March 8, 2022
File No. 21-004.200

**Subject: Response to City of Mercer Island Comments
Re-Cantilever Soldier Pile Wall over 10 feet
9611 SE72nd Street
Mercer Island, WA**

SHEET TITLE:
Shoring Plan

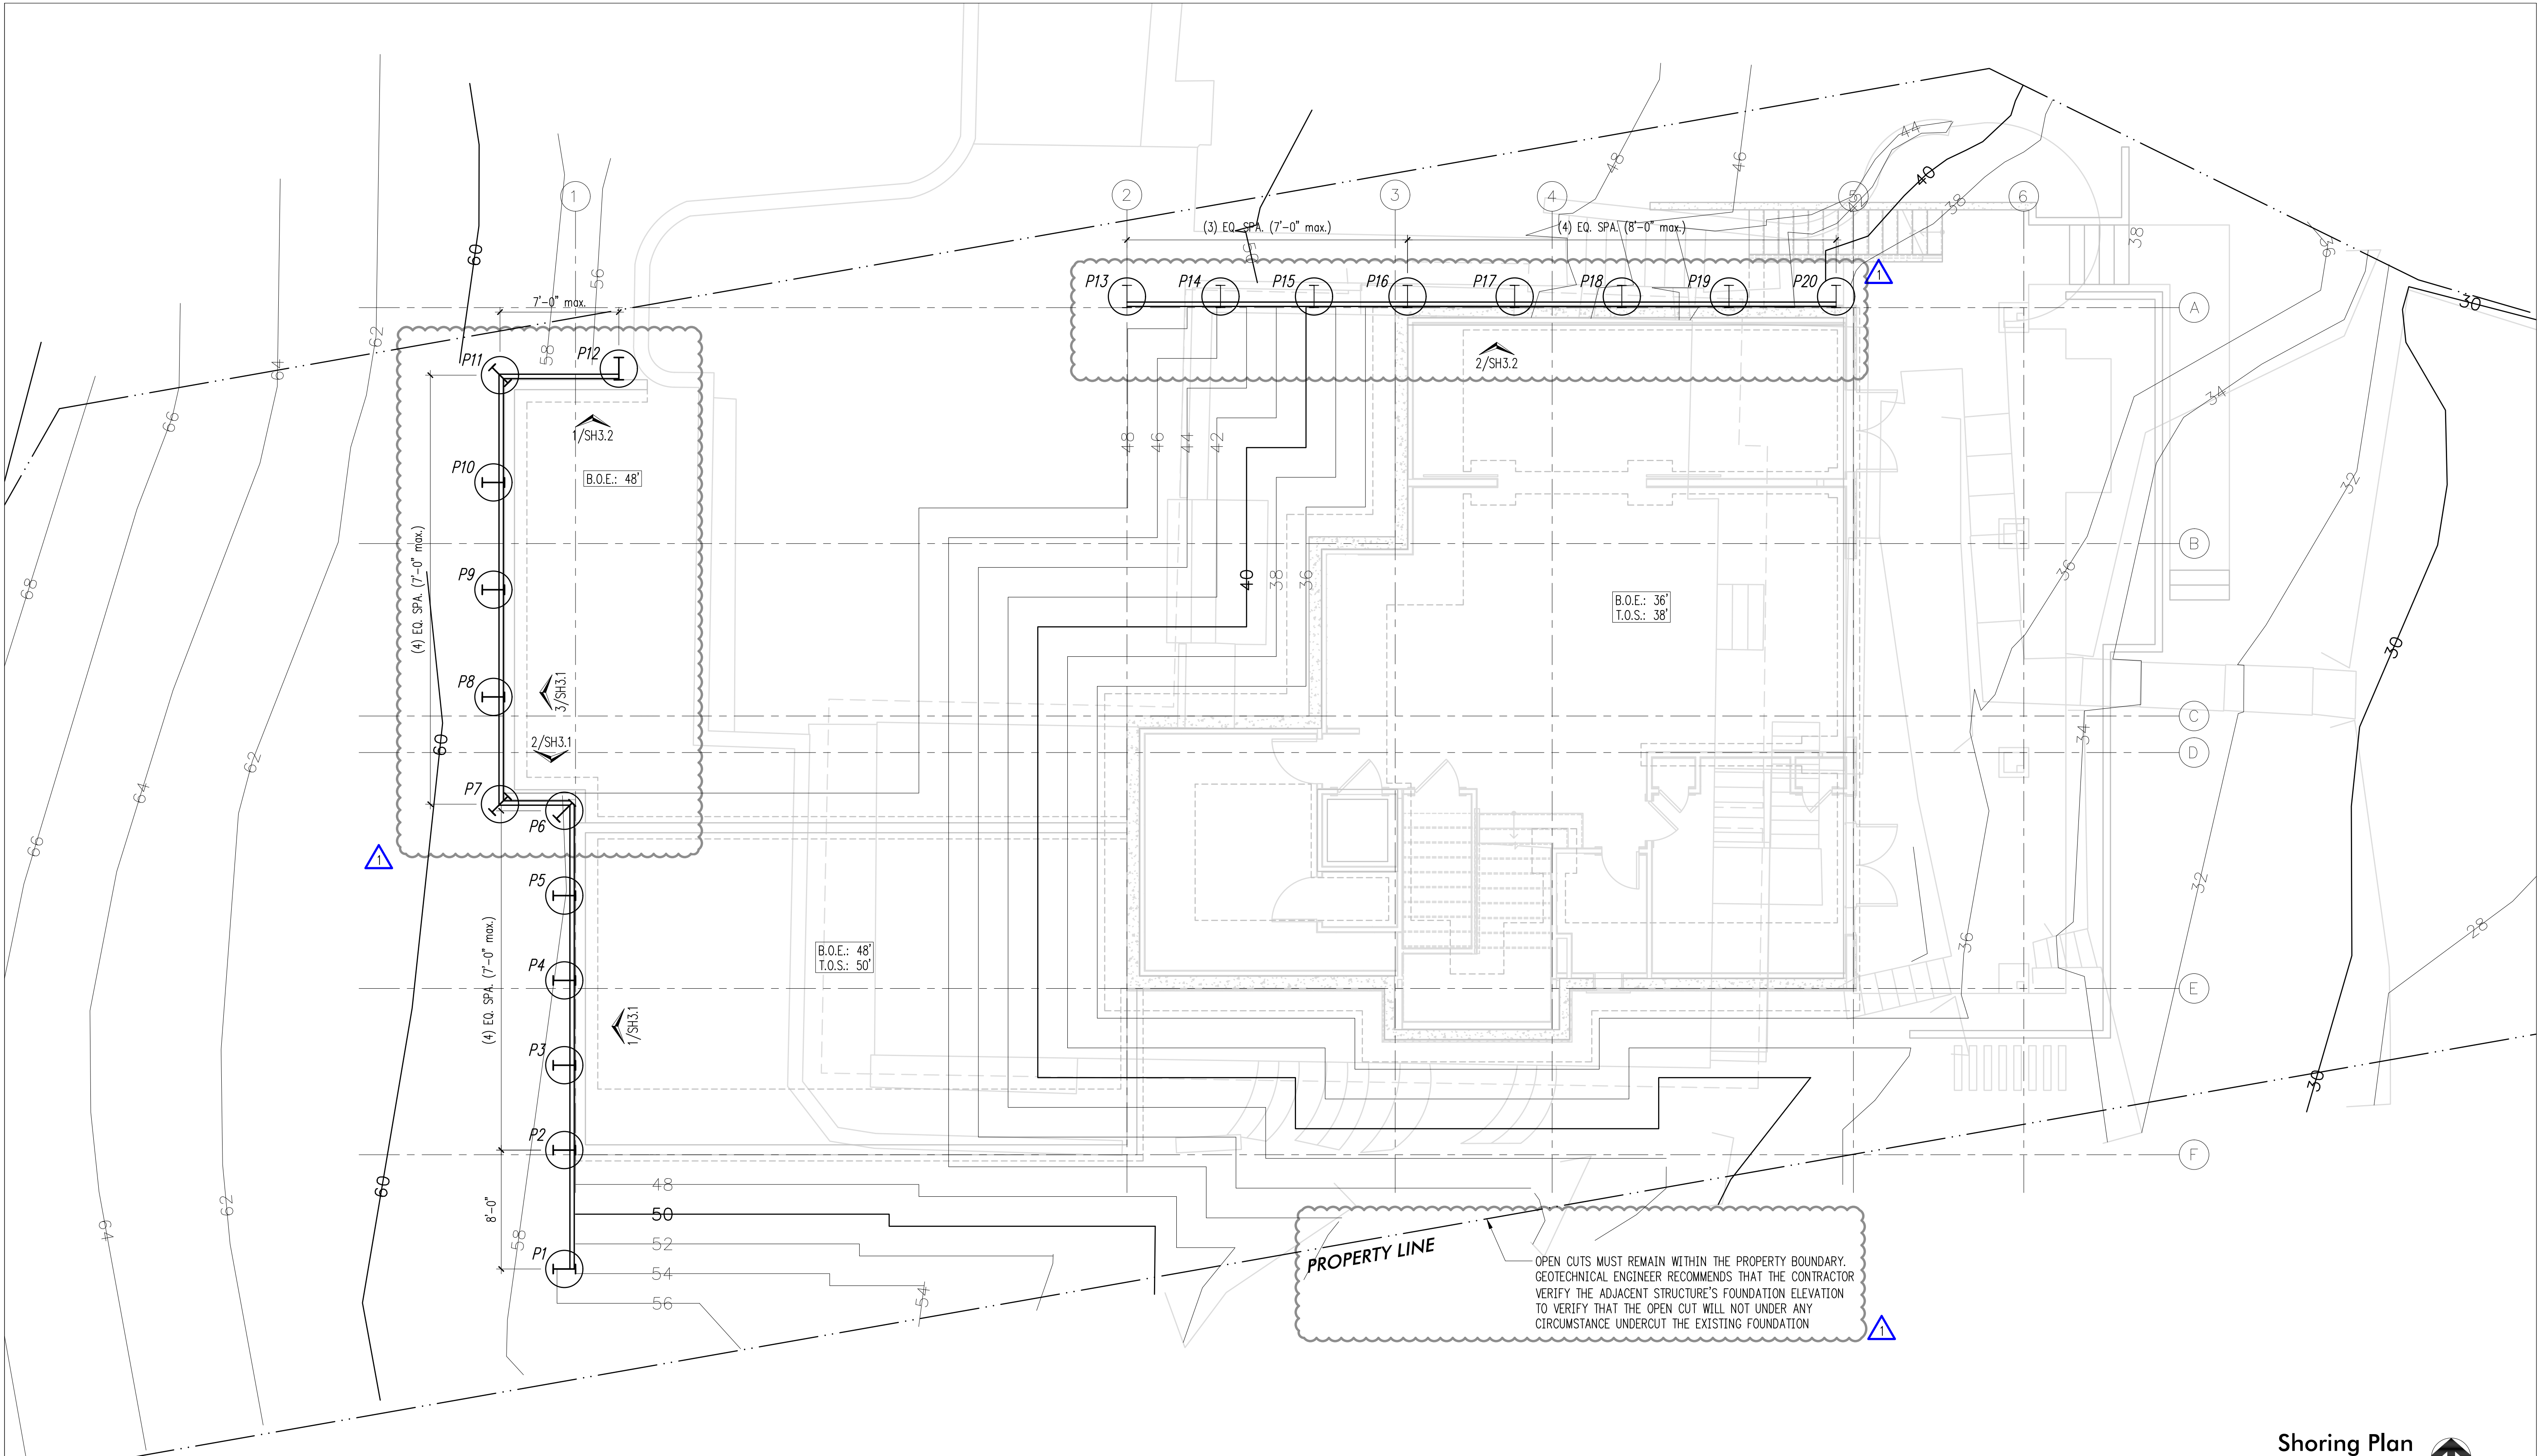
Accordingly, we have reviewed the September 14, 2021, structural plans and calculations for the permanent and temporary cantilever soldier pile walls for the above property and, in our opinion, the design of the soldier pile walls is consistent with the recommendations in our geotechnical design report.

However, we expect that soldier pile drilling will require casing or drilling mud to address groundwater the upper portions of piles P1 through P12. Also, dewatering may be needed to complete lagging installation for these piles.
